CITY OF PORTLAND

November 2, 2001

RE: Permit #01-1309 (028 P021)

PLAN VIEW

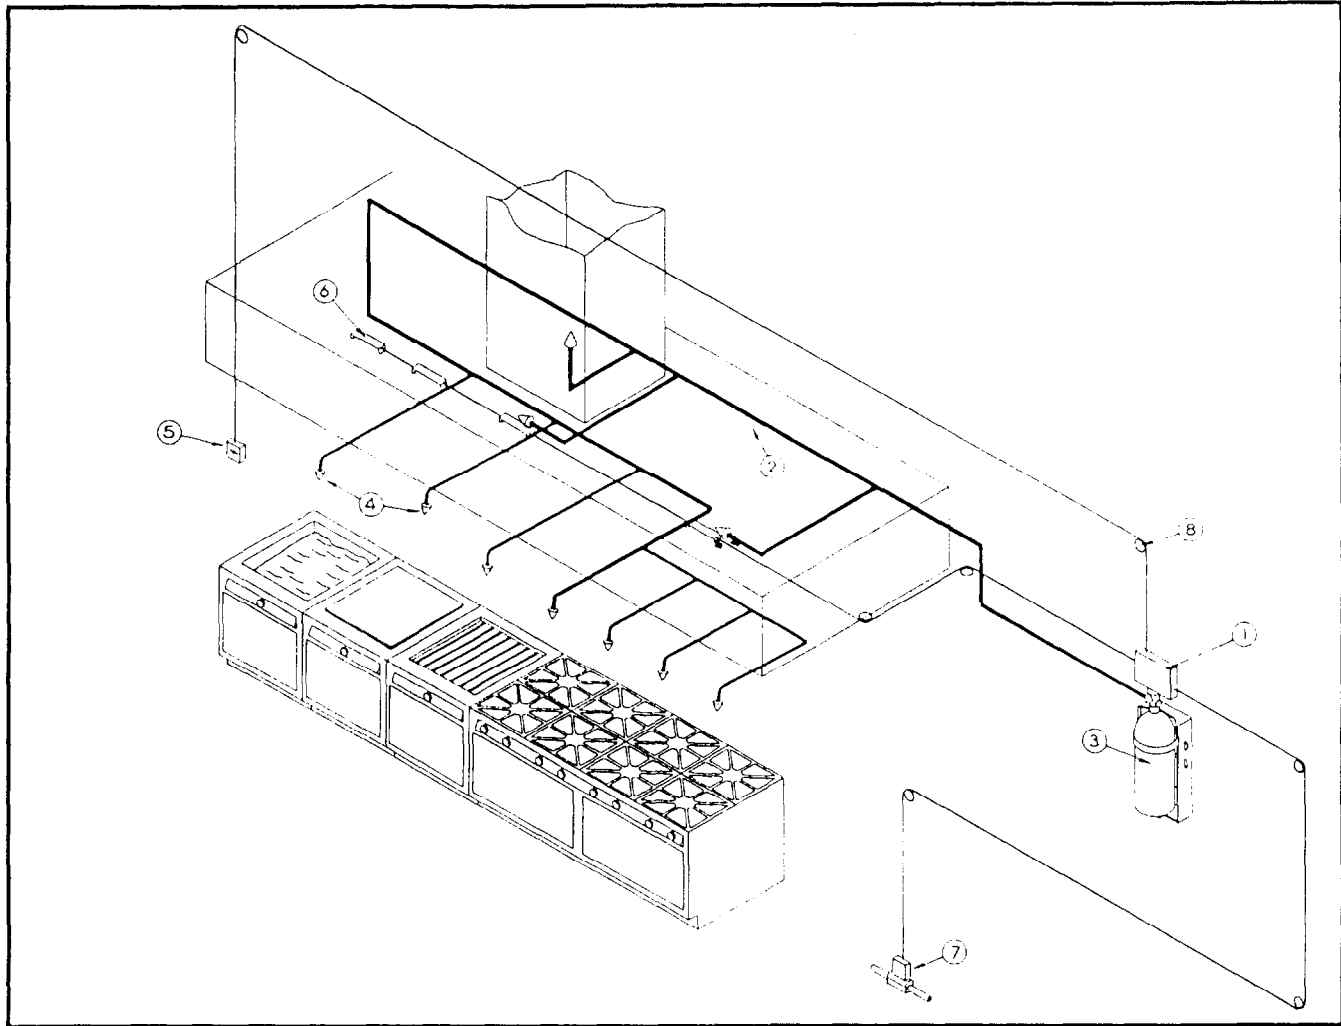
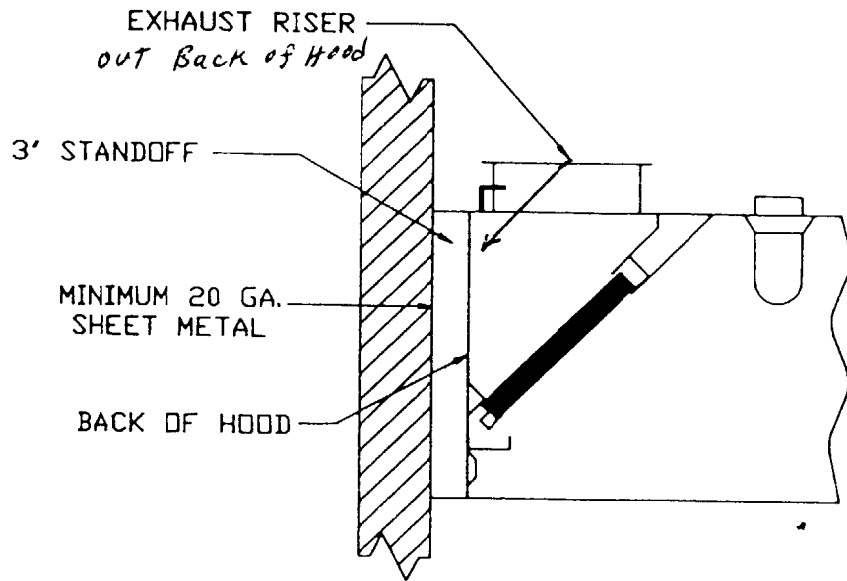
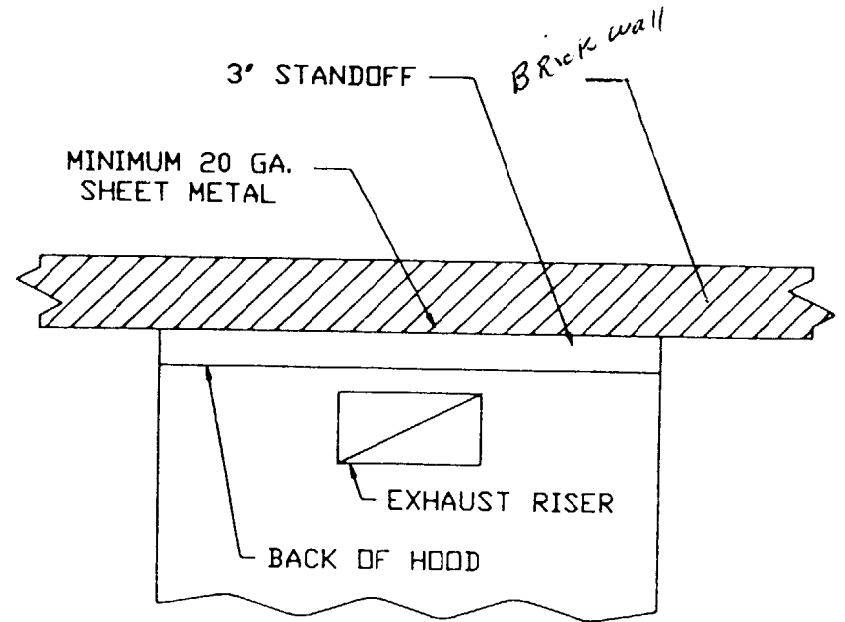
With regard to your request for waiver of the 10' clearance above grade for the kitchen exhaust system for the above existing structure pursuant to Section 121.1 of the Building Code, this office grants the request to be at least 8' above grade, as there is practical difficulty in complying with this standard while providing 18" of clearance from combustibles and 36" of clearance from openings. Please contact this office when the system is opened up to allow the area inspector to view the wall penetration to insure clearance from combustibles.
